Road Safety Audit Report

**Mixed-Use Development,
Hills Showground Station Precinct**

Issue 2: June 2021

UPPER LEVEL PLAN
 PROPOSED RETAIL & COMMERCIAL
 DORAN DRIVE PRECINCT
 DORAN DRIVE, CASTLE HILL NSW 2154
 FOR DEICORP PROJECTS (SHOWGROUND) PTY LTD
 21015 SK 1.05 G

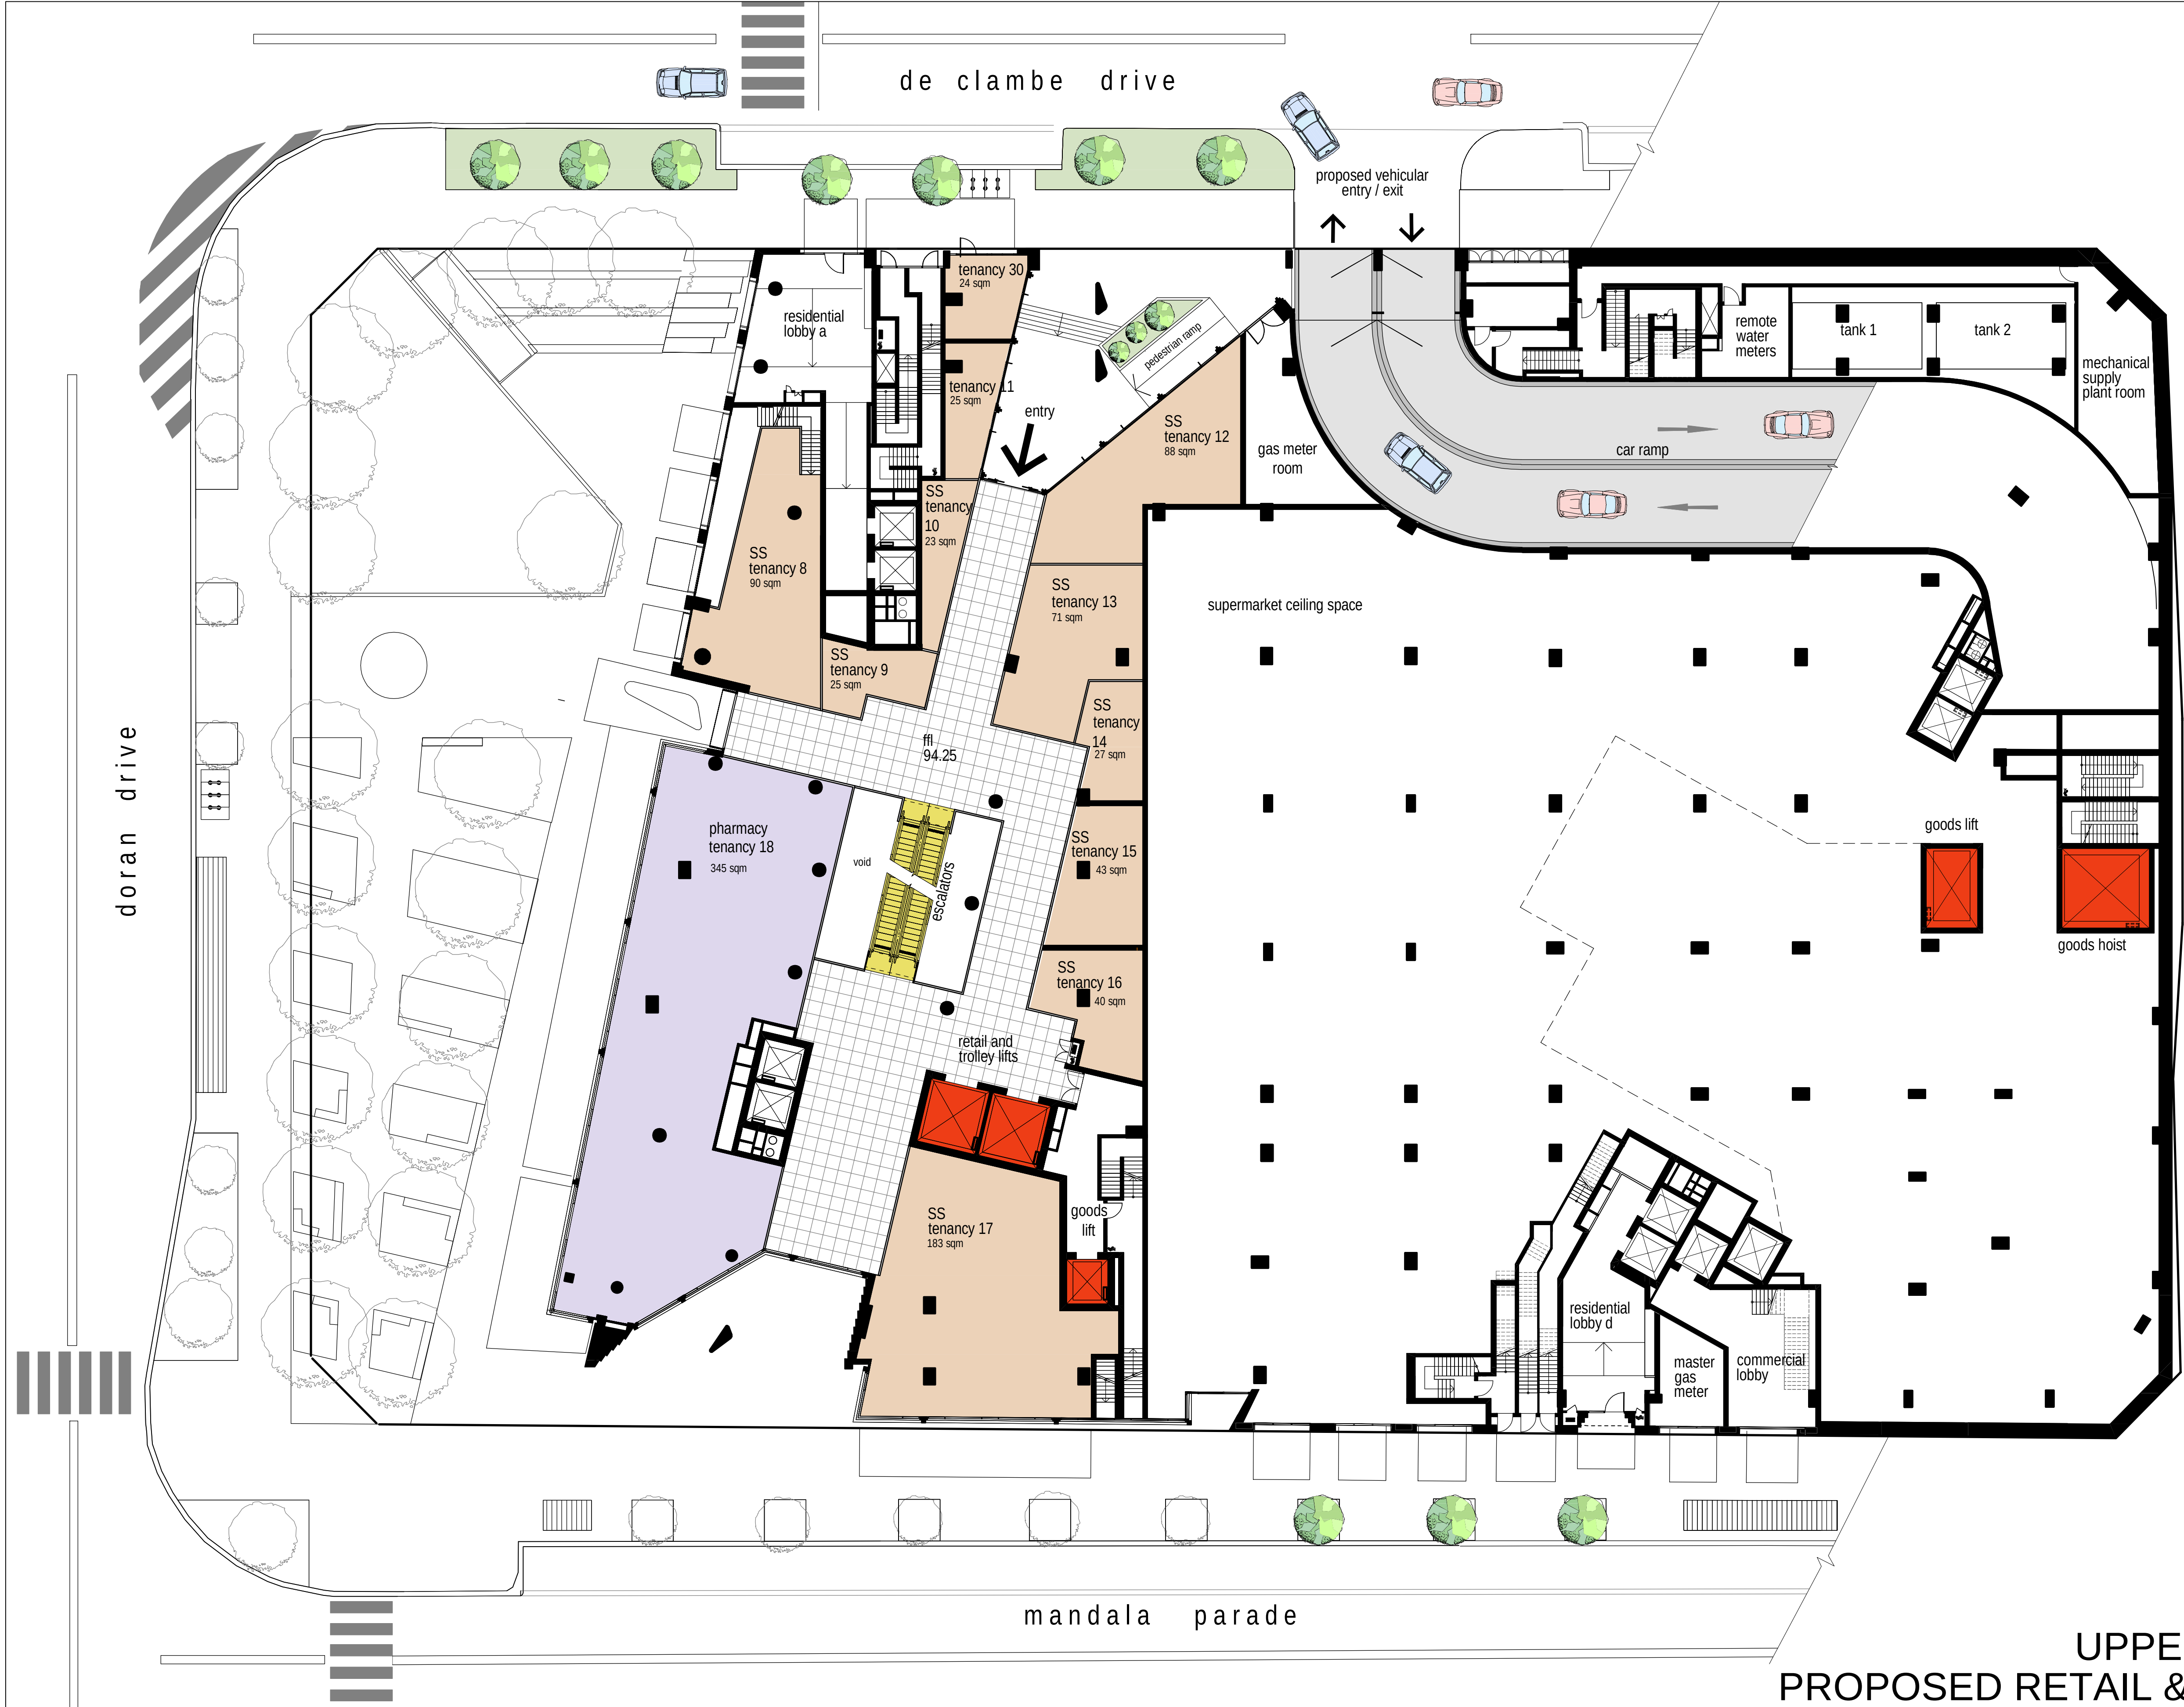
Ref No.	Photos / Site Description / Safety Issue	Description of risk to road safety (Reason why this is a safety issue)	Road Safety Audit Category	Probability	Severity	Risk Rating
1b	 <p>Above: Extract from the upper-level plan showing the various pedestrian access-egress points from the mixed use development to De Clambe Drive.</p>	<p>Further to item 1a, there are also pedestrian access-egress points from the upper level.</p> <p>Examples of pedestrian crossing decisions are discussed as follows with respects to the design extract (upper floor level) to the left.</p> <ul style="list-style-type: none"> The 1:20 ramp from RL 94.000 to the southern footpath of De Clambe Drive leads pedestrians directly into the outbound lane from the basement car park. If the clear sight triangle/ zone is unobstructed (ie. clear space), this may even allow pedestrians to emerge suddenly into the path of the outbound vehicle. The pedestrian may also resort to a diagonal and prolonged crossing path over the driveway ramp. This would have increased exposure to vehicle-pedestrian crashes. Further to the above point, even if the pedestrian enters the footpath first before crossing the driveway, they may emerge from behind the sight-obstructing column (red rectangle). The column may obscure them from the visibility of outbound drivers. 	Pedestrian infrastructure	Yearly	Serious	Medium

Ref No.	Corrective Action Response (CAR)	Priority for action (To be completed by Project Manager)	Residual risk (if any)
1	Publicly accessible plaza has been redesigned to conduct the pedestrians to the safe crossing points.	Immediate	N/A
2	Pedestrian sight lines and car sightlines have been incorporated.	Immediate	N/A
3	Mirrors and flashlights have been provided.	Immediate	N/A
4	Truck size has been decreased to 12.5m from 17.5m. This has a positive result on the swept path of the trucks existing the loading dock.	Immediate	N/A
5	Trees will be regularly maintained to ensure sightlines are not interrupted.	Immediate	N/A
Project Manager / Sponsor Name		Poonam Chauhan	Signature
Concurring Client Name		Greg Colbran	Signature
